PRE-APPLICATION ENQUIRY DC/20/05606

Edge House, Dublin Road, Rishangles, Eye Suffolk IP23 7QB

Pre-application Enquiry

Written response - Conversion of barn to dwelling

BLOCK PLAN Scale 1:200

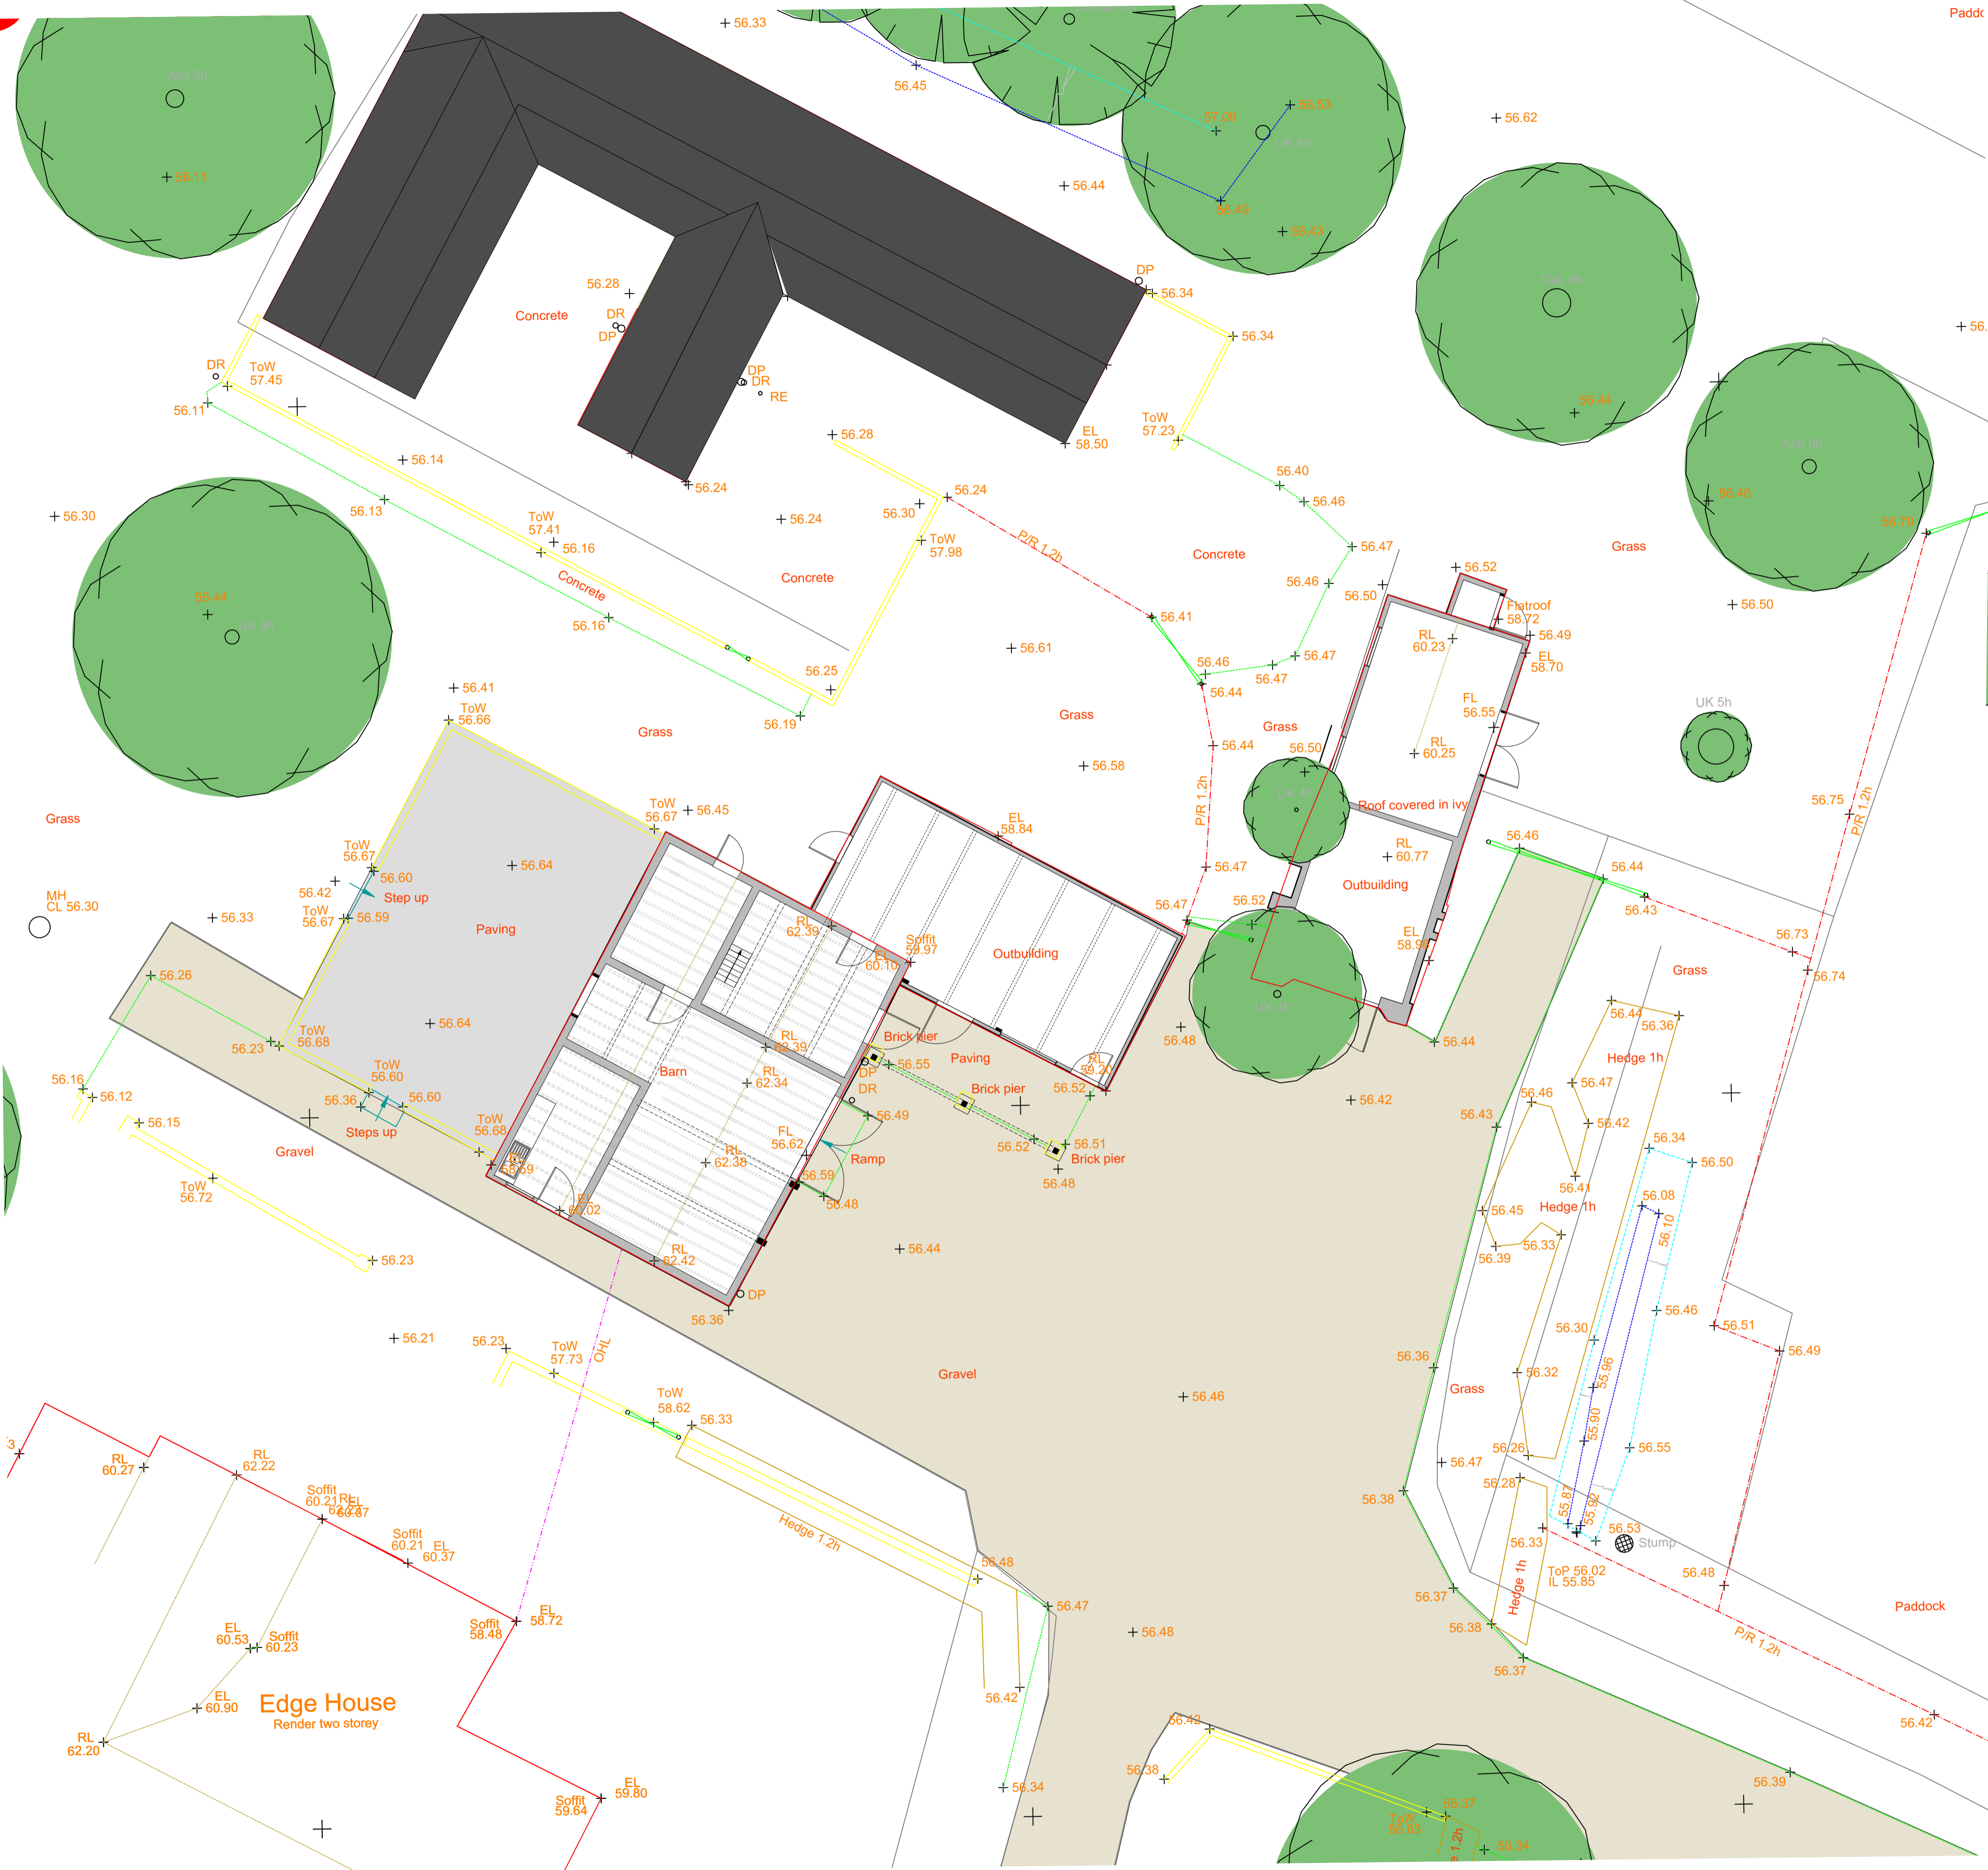
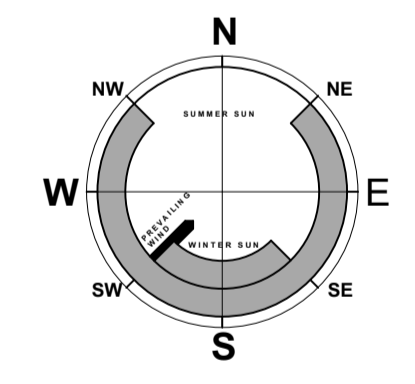
Based on the submitted plans it is believed that the existing barn could meet the criteria although careful attention should be paid to the cumulative floorspace as this cannot exceed 465 square metres. It is noted that on the submitted site location plant, the red line depicts not only the access but also a small area surrounding the barn. The proposed curtilage cannot be any larger than the floor space of

the barn which is to be converted, this is part of the criteria set out in section X of Schedule 2, Part 3 and therefore it is recommended that any proposed block plan submitted as part of the application should indicate a suitable curtilage area which also includes parking spaces.
